KH Responses

EL PASO COUNTY GRADING AND EROSION CONTROL PLAN CHECKLIST

EPC Project Number: PPR-22-009 KH: Added

**INITIAL EROSION CONTROL PLAN**

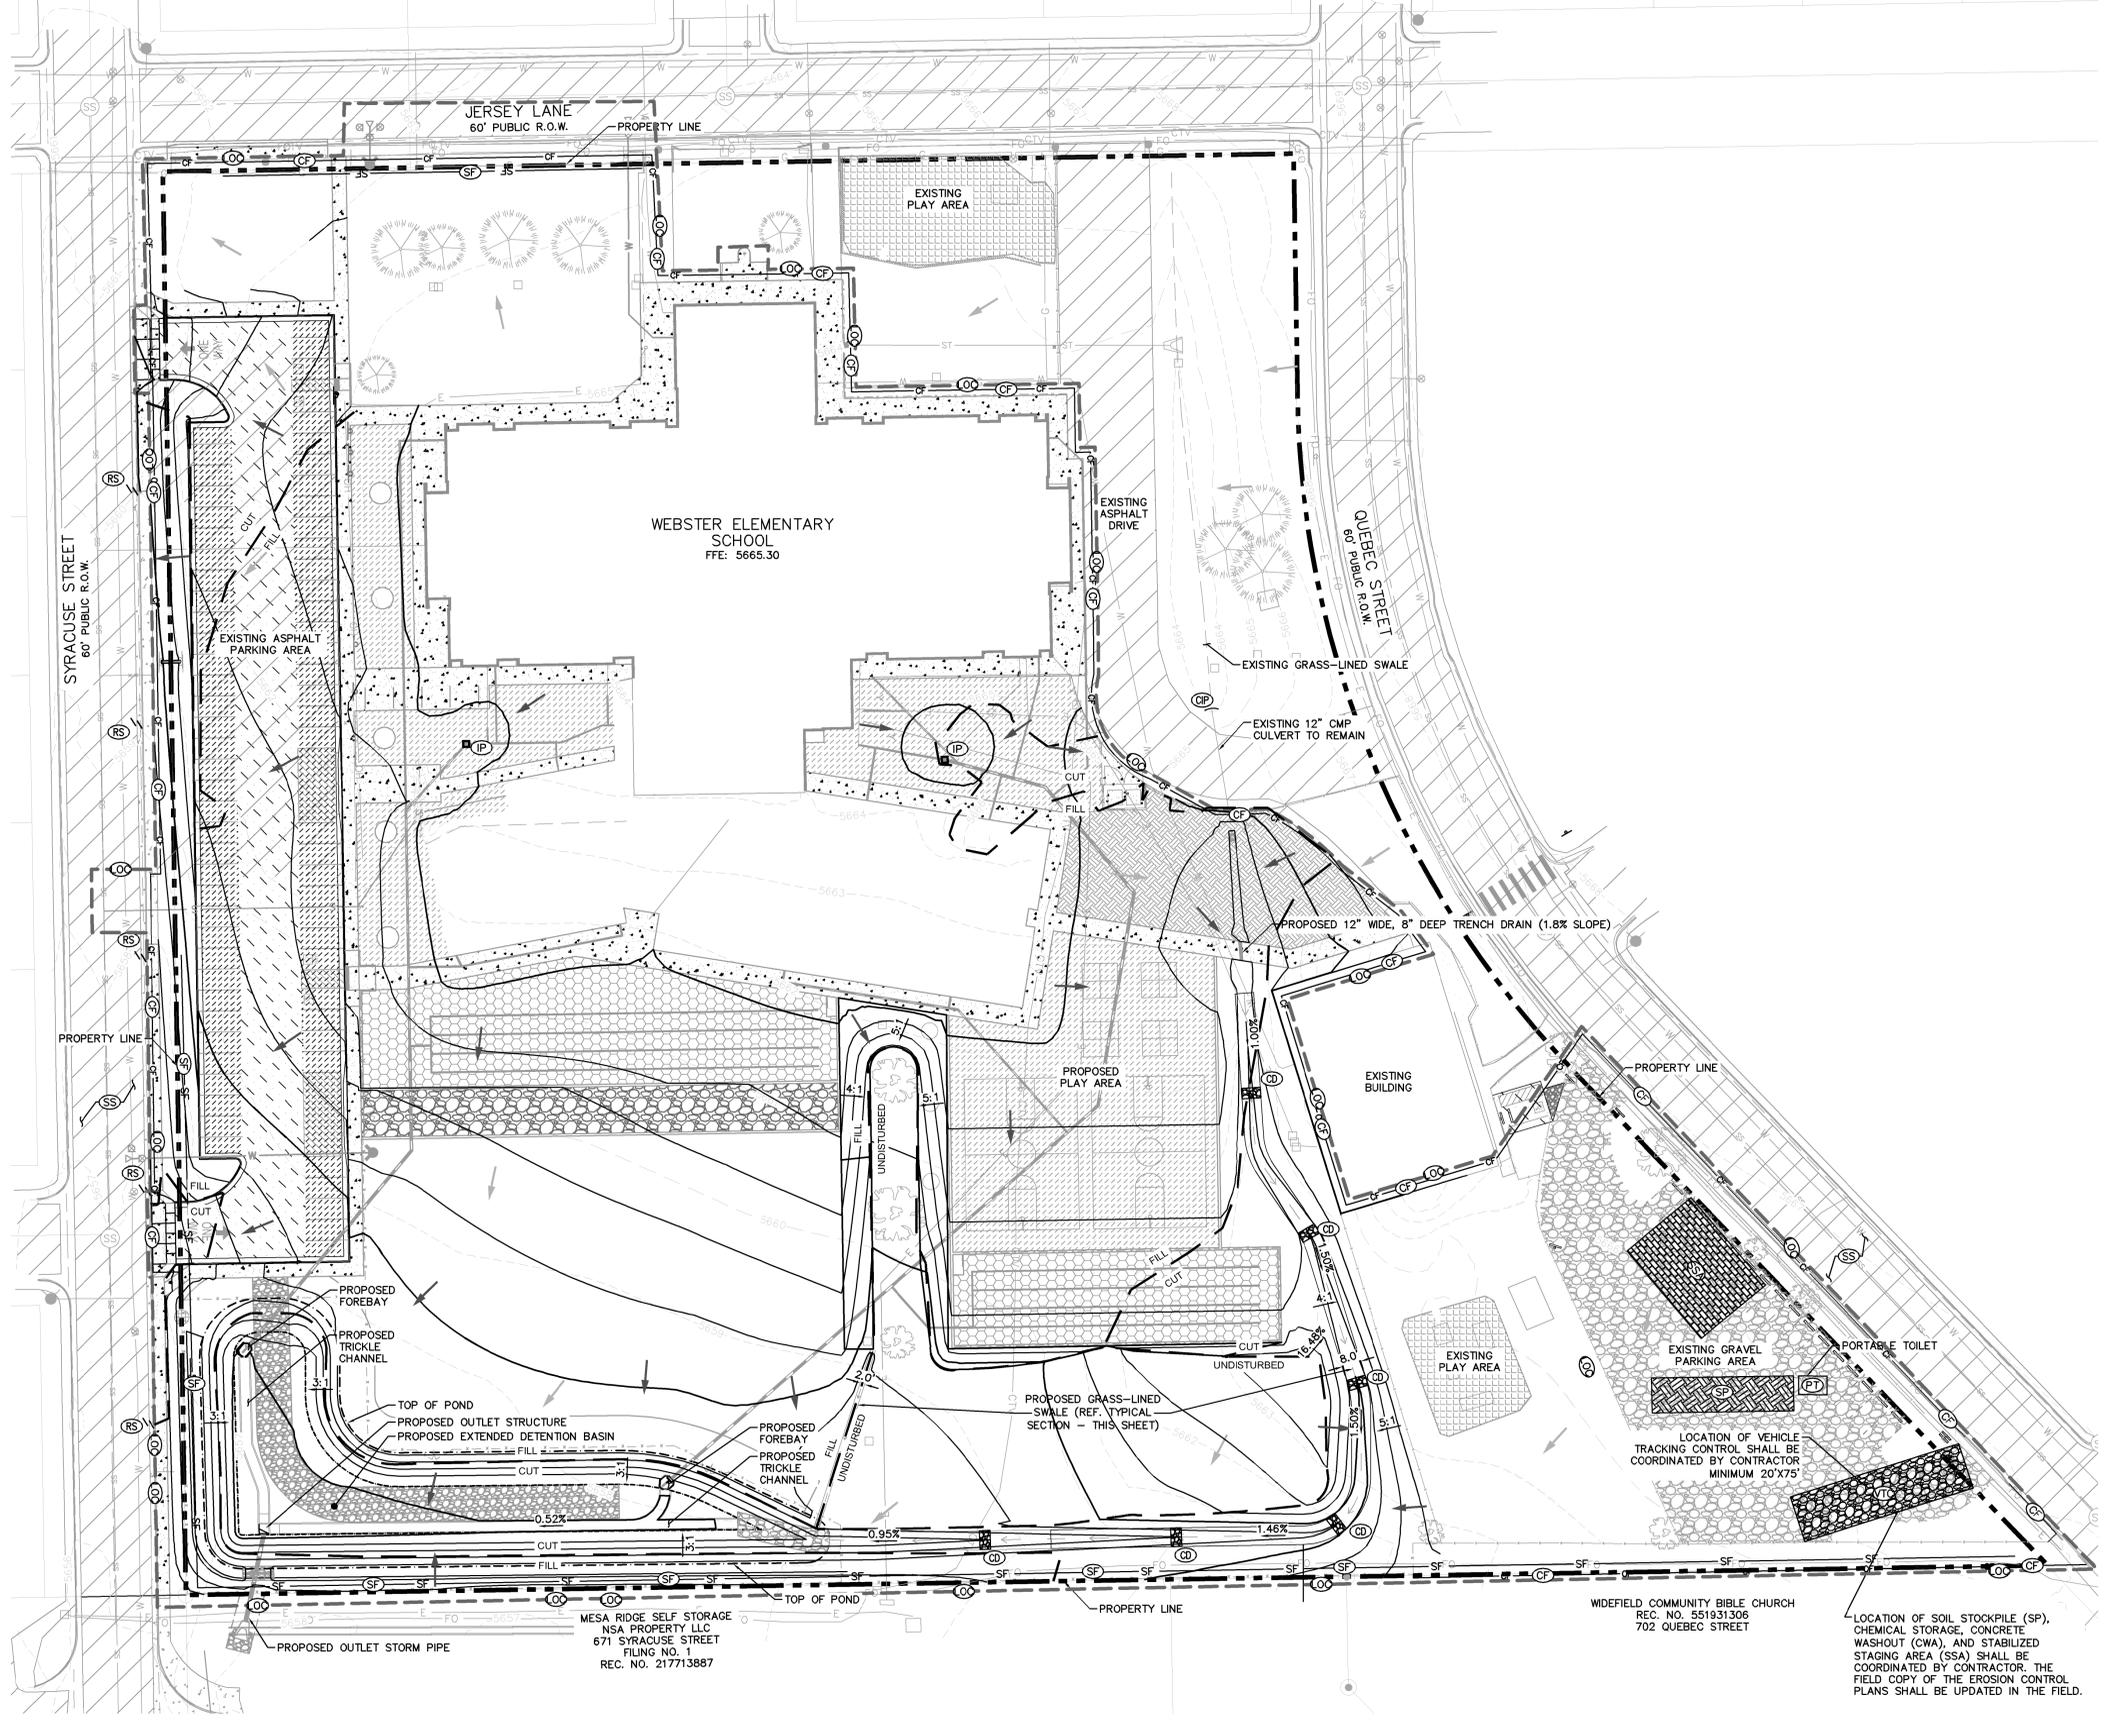
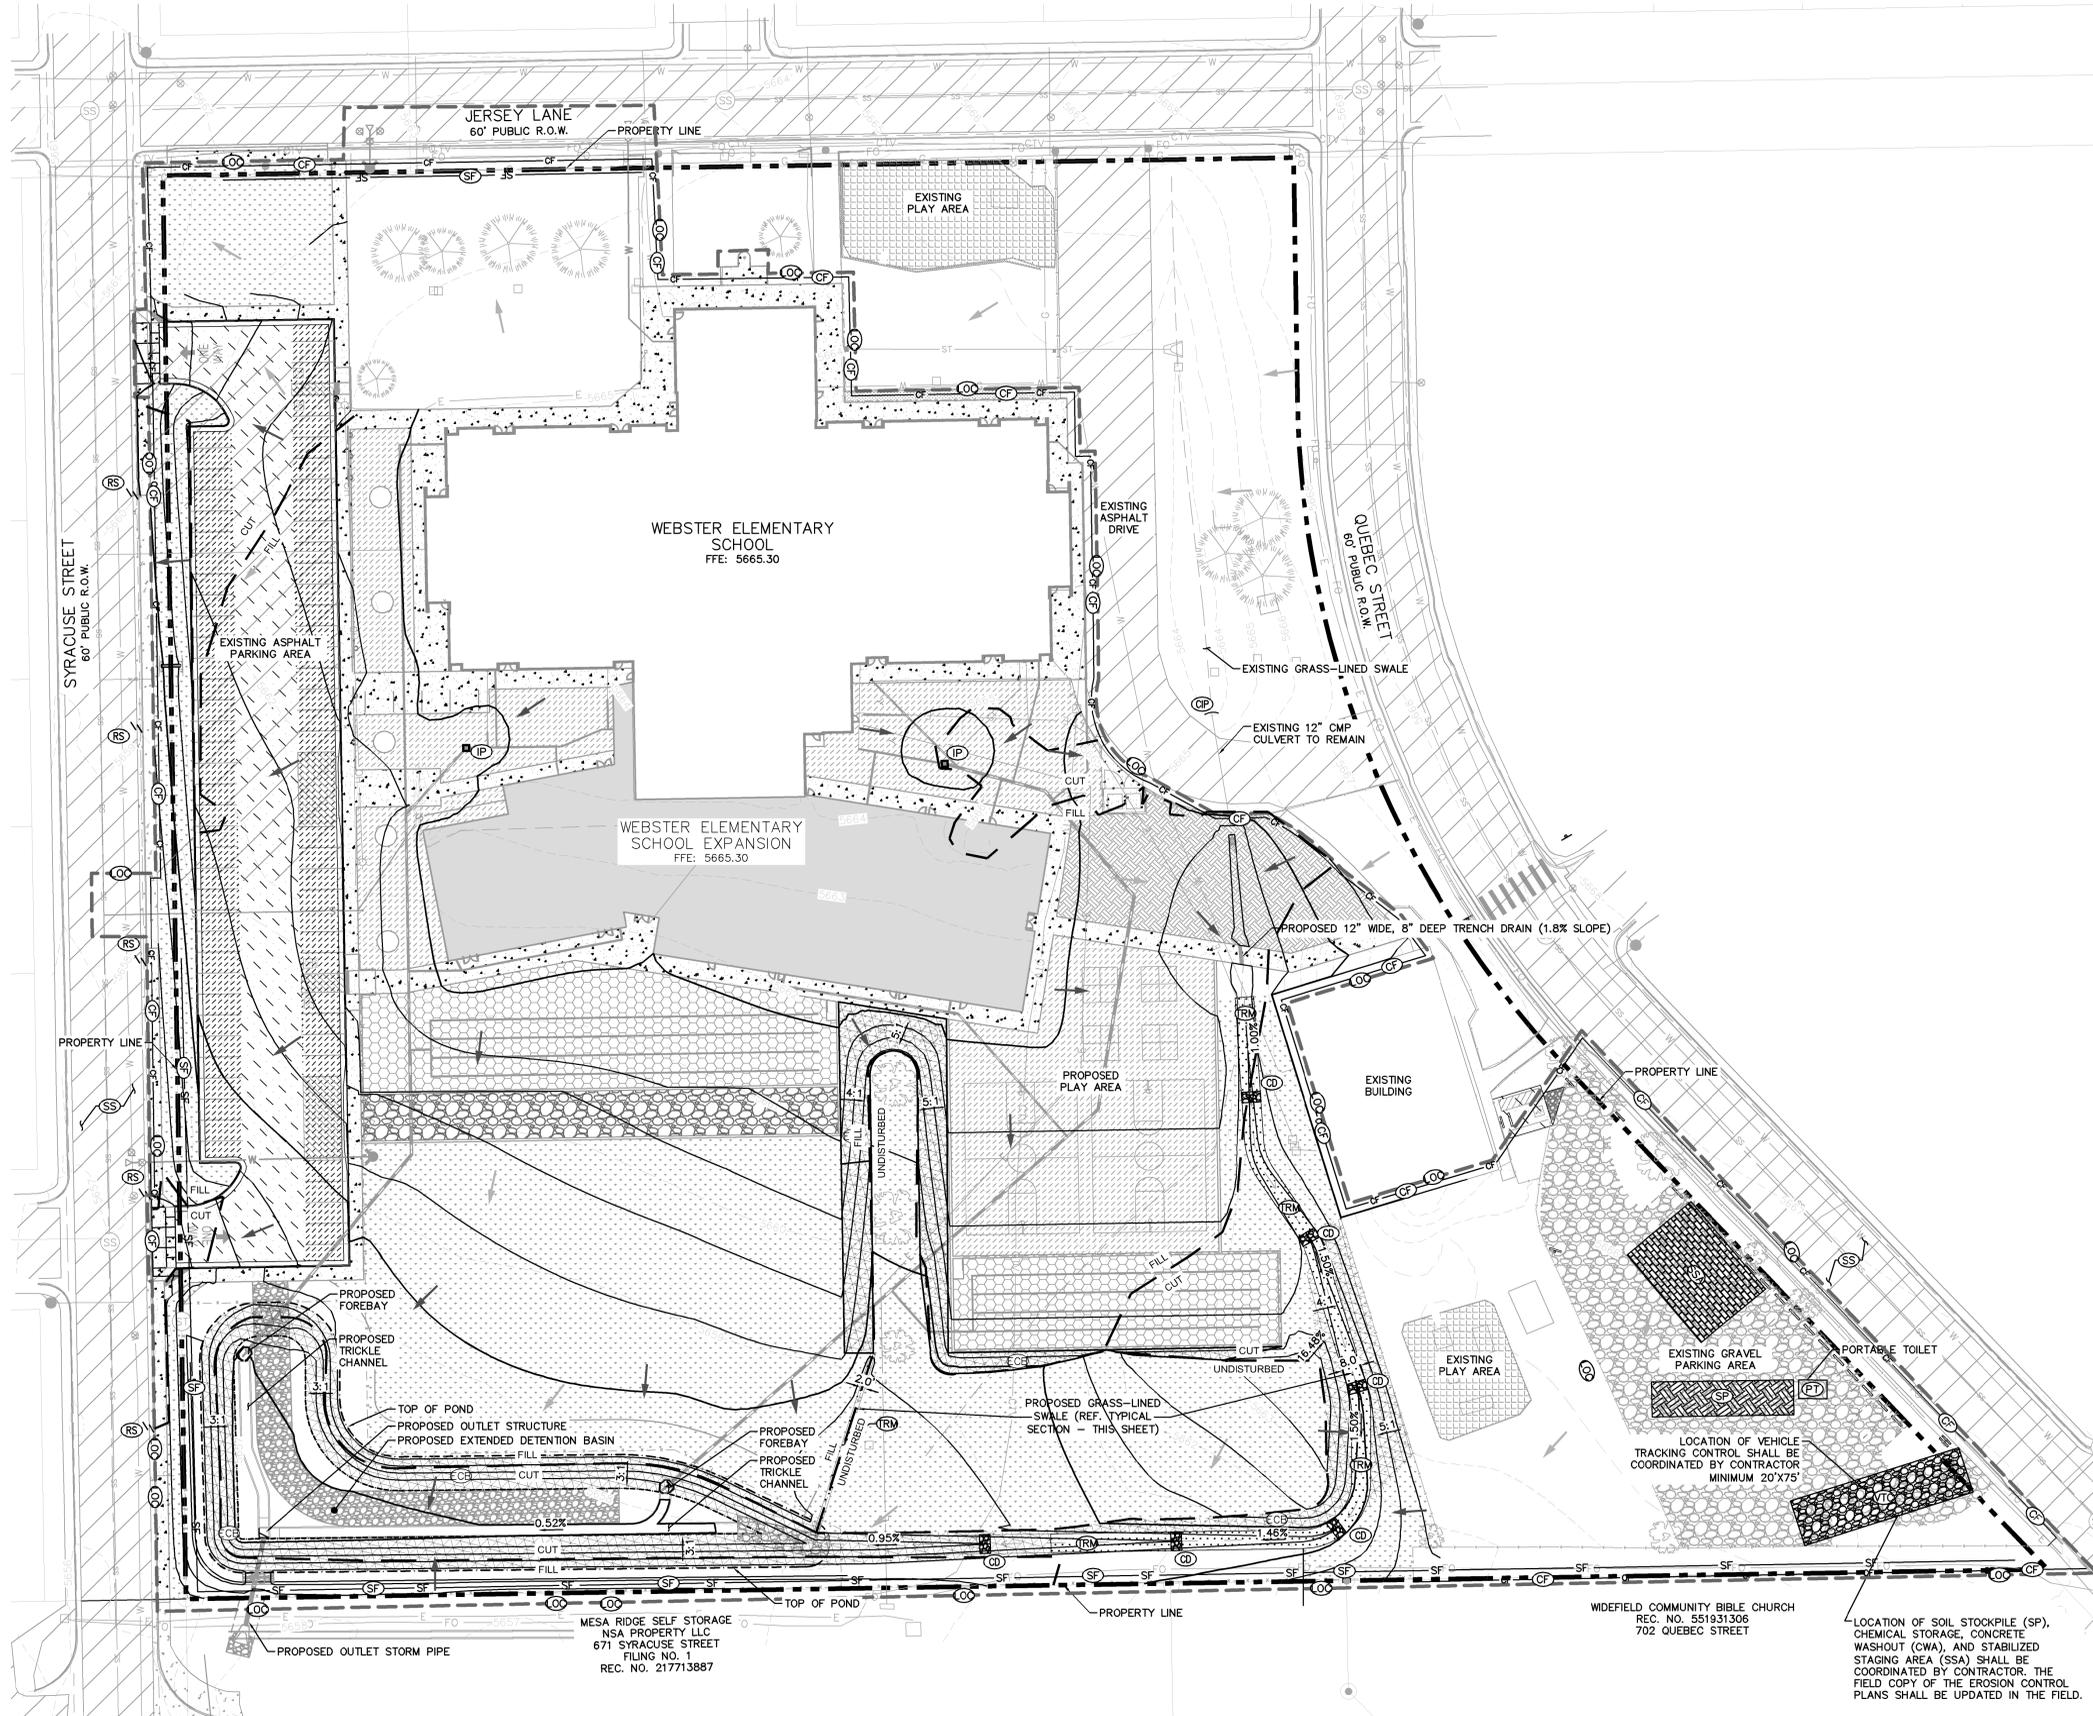
v	All proposed temporary construction control measures, structural and non-structural. Temporary construction measures shall be identified by phase of implementation to include "initial," "interim," and "final" or shown on separate phased maps identifying each phase KH: Added		X
w	Vehicle tracking provided at all construction entrances/exits. Construction fencing, barricades, and/or signage provided at access points not to be used for construction		X
x	Temporary sediment ponds provided for disturbed drainage areas greater than 1 acre KH: Added		X
